CITY OF ALBUQUERQUE

RE: **Lot 25 Block 6 Unit 18 SAD 228**
6601 Petirrojo Rd. NW
Volcano Cliffs Subdivision
Grading and Drainage Plan
Engineers Stamp Date 5/13/2020 (D10D00311)
Pad Certification Date 5/28/2020
Revised Plan for Pool Date 1/22/2021

6601 Petirrojo Rd. NW  
Grading & Drainage Plan

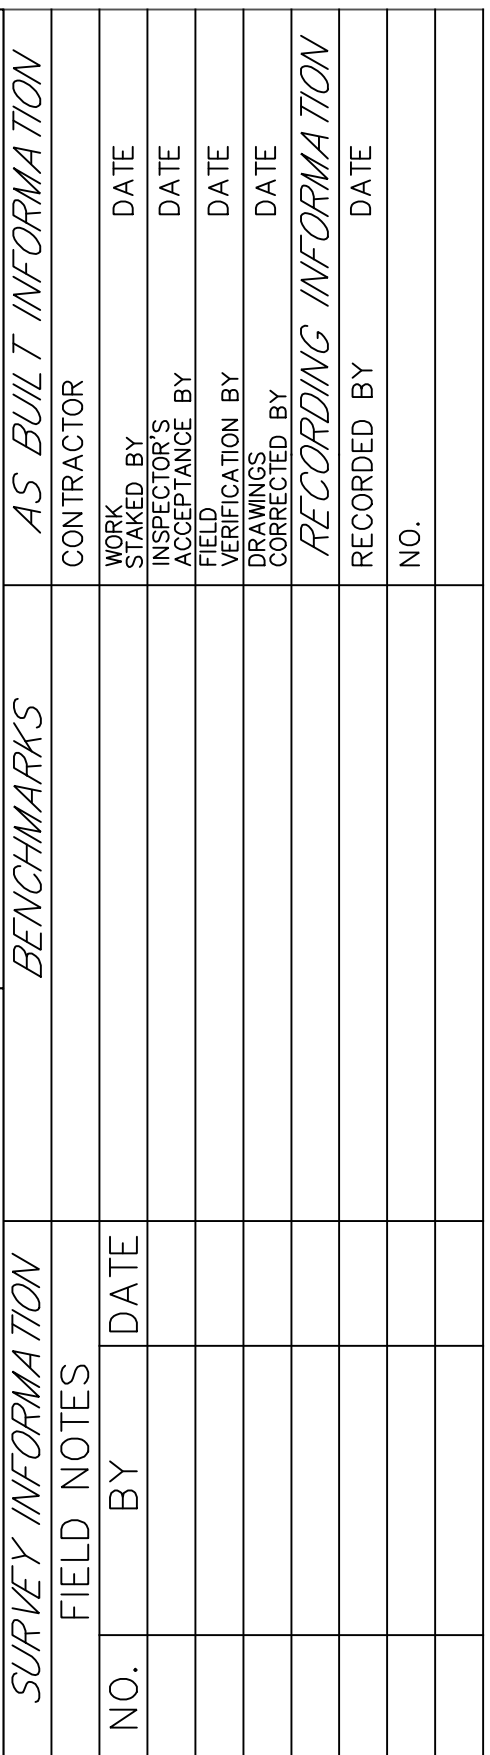
- Provide the bottom and top of new ponding area.
- Provide the volume of the pond.
- Show the approximate area of the pond.
